Rezoning Transportation Analysis

Petition Number: 2023-047

From: Jake Carpenter, PE

Date	Description
8-24-23	First Review (IW)
11-21-23	Second Review (IW)

SHEET NUMBER:
RZ-2

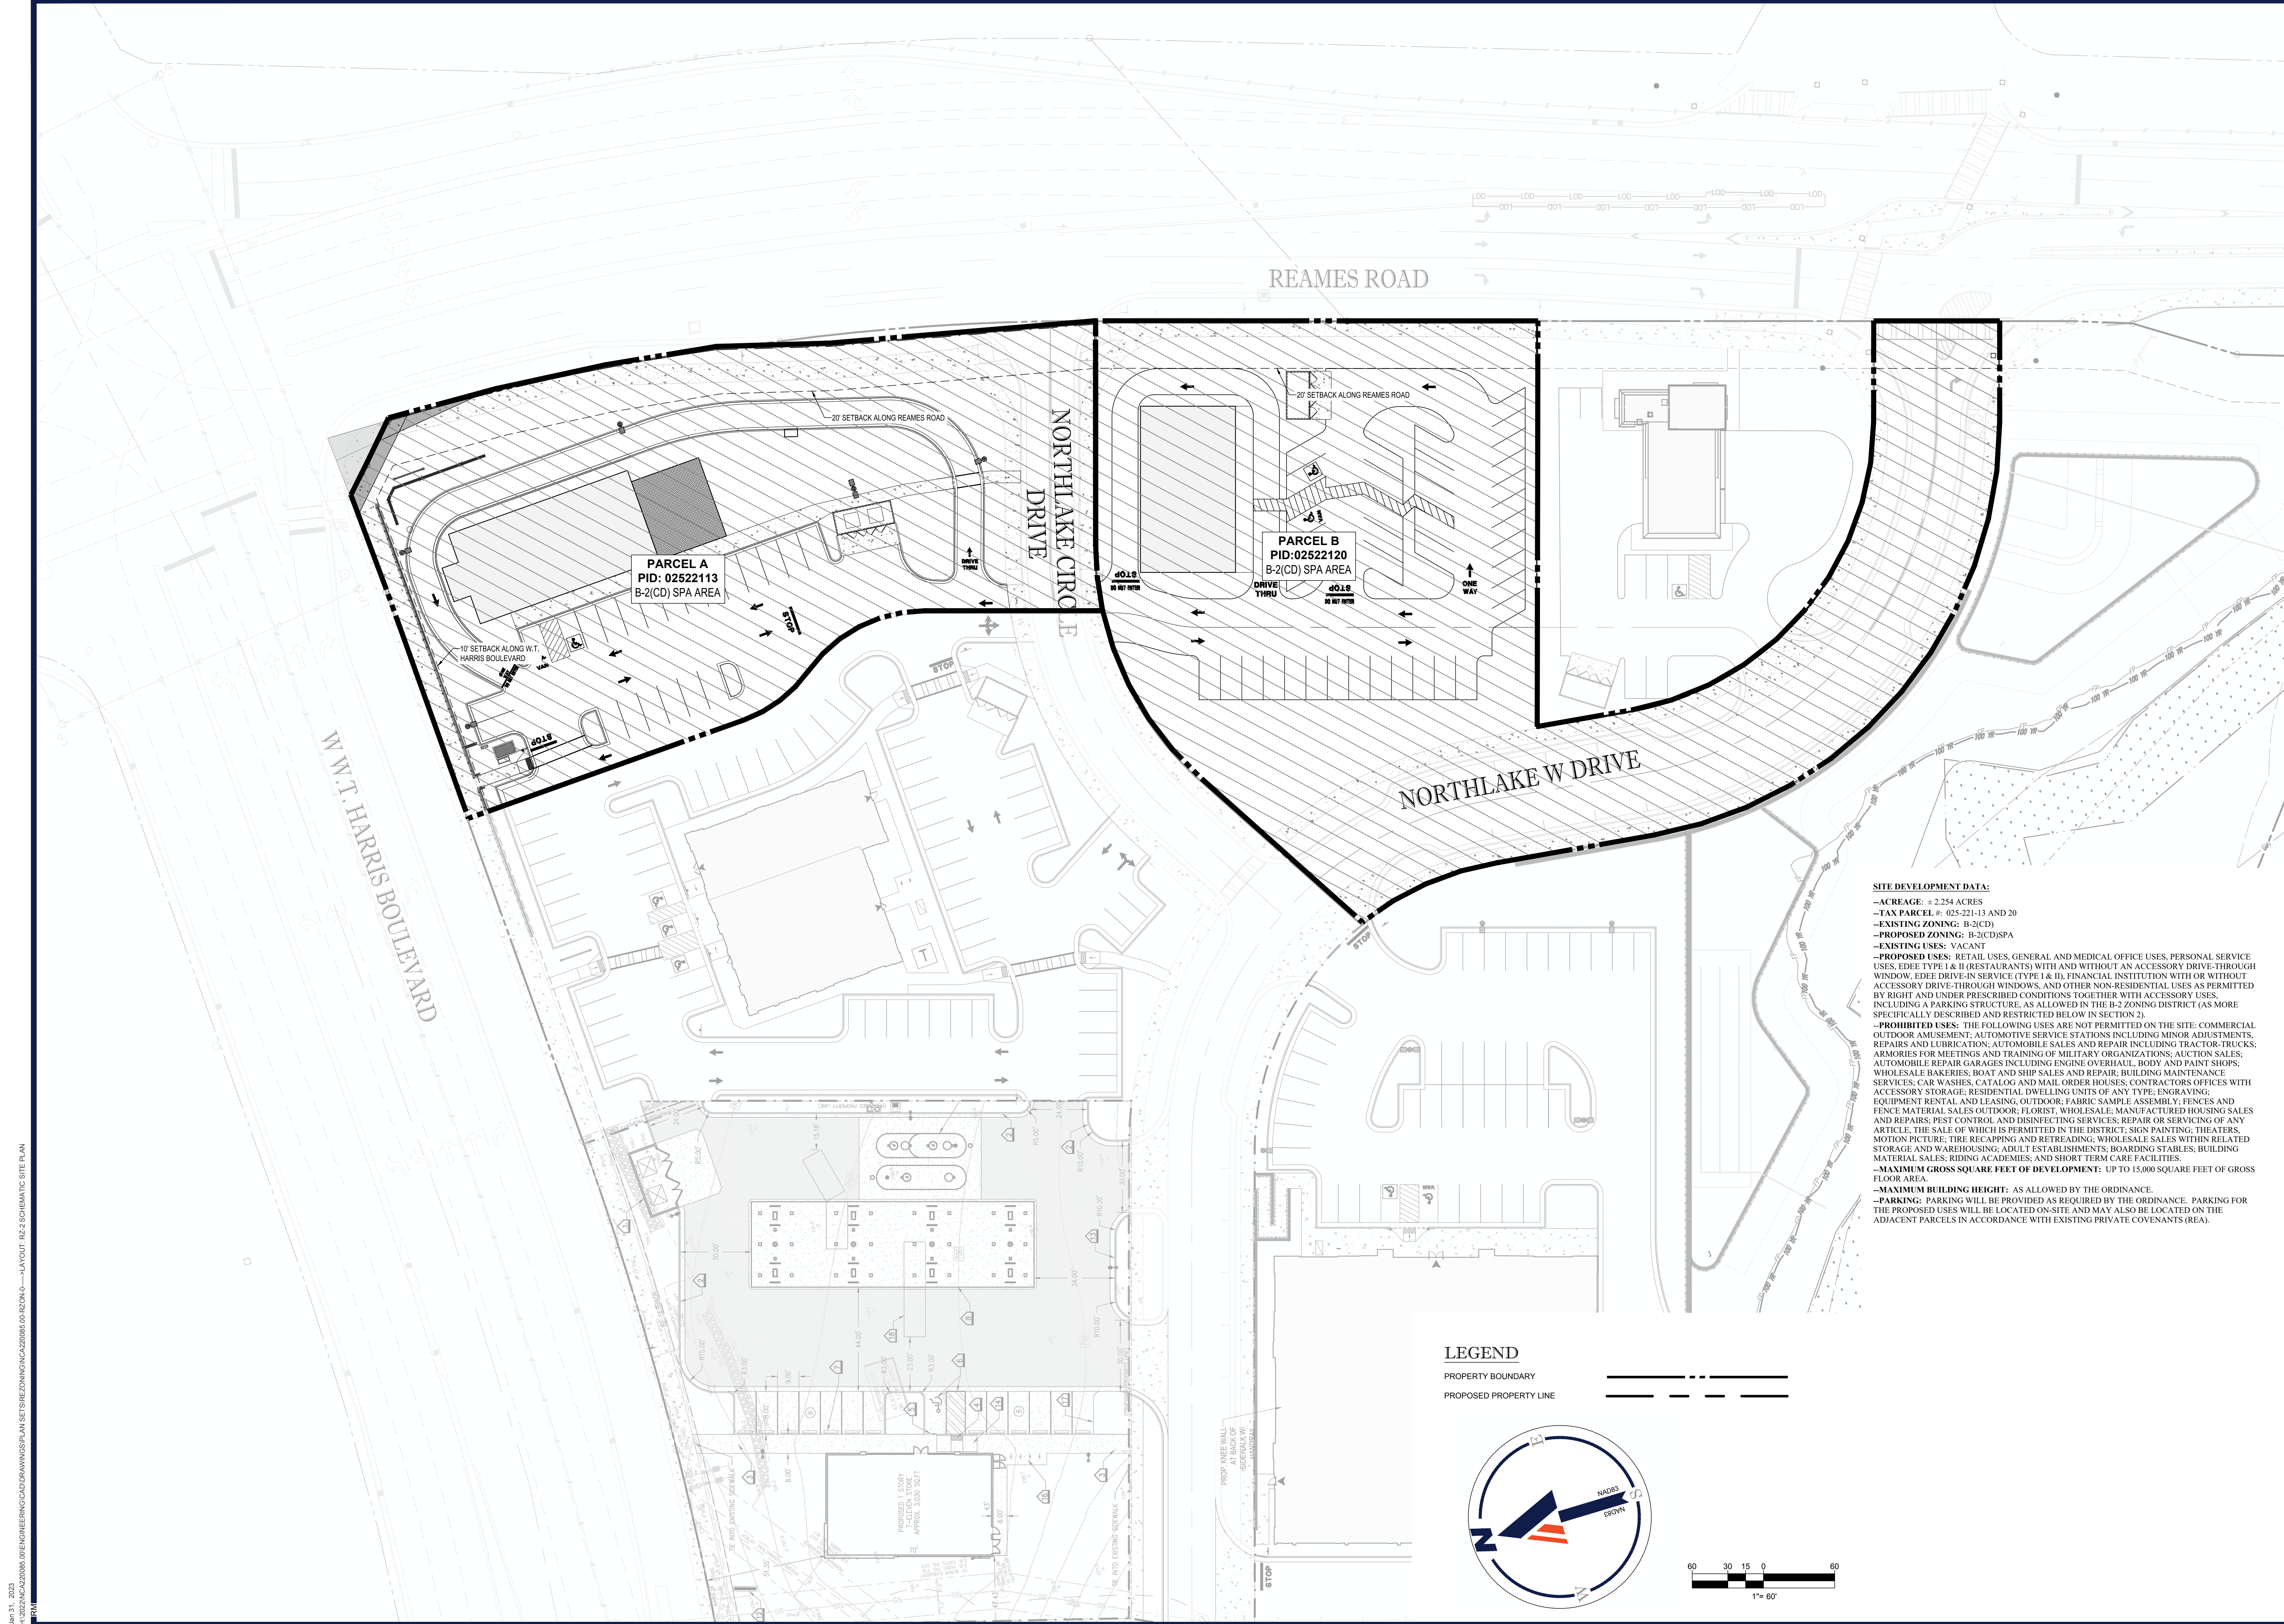
1. **Outstanding Comment from 08-24-23: Curblines:**

- a. **W T Harris Blvd:** Location of future back of curb and gutter to be 44 feet from roadway centerline to accommodate the Charlotte Streets Map with a roadway typical section of 6+ Boulevard, Shared Use Path.
- b. **Reames Road:** Location of future back of curb and gutter to be moved to 38 feet from roadway centerline to accommodate the Charlotte Streets Map with a roadway typical section of 4+ Avenue, Buffered/Separated Bike Lanes.

Label and dimension the curb and gutter from the centerline for each road on the site plan.

Clarifying Comment: Site plan needs to Label and dimension the curb and gutter from the centerline for each road on the site plan.

4. **Outstanding Request:** CDOT is requesting that the petitioner revise site plan and conditional note(s) to commit to upgrading the construction curb ramps and installing pedestrian signals for the Reames Road and W T Harris Blvd intersection.
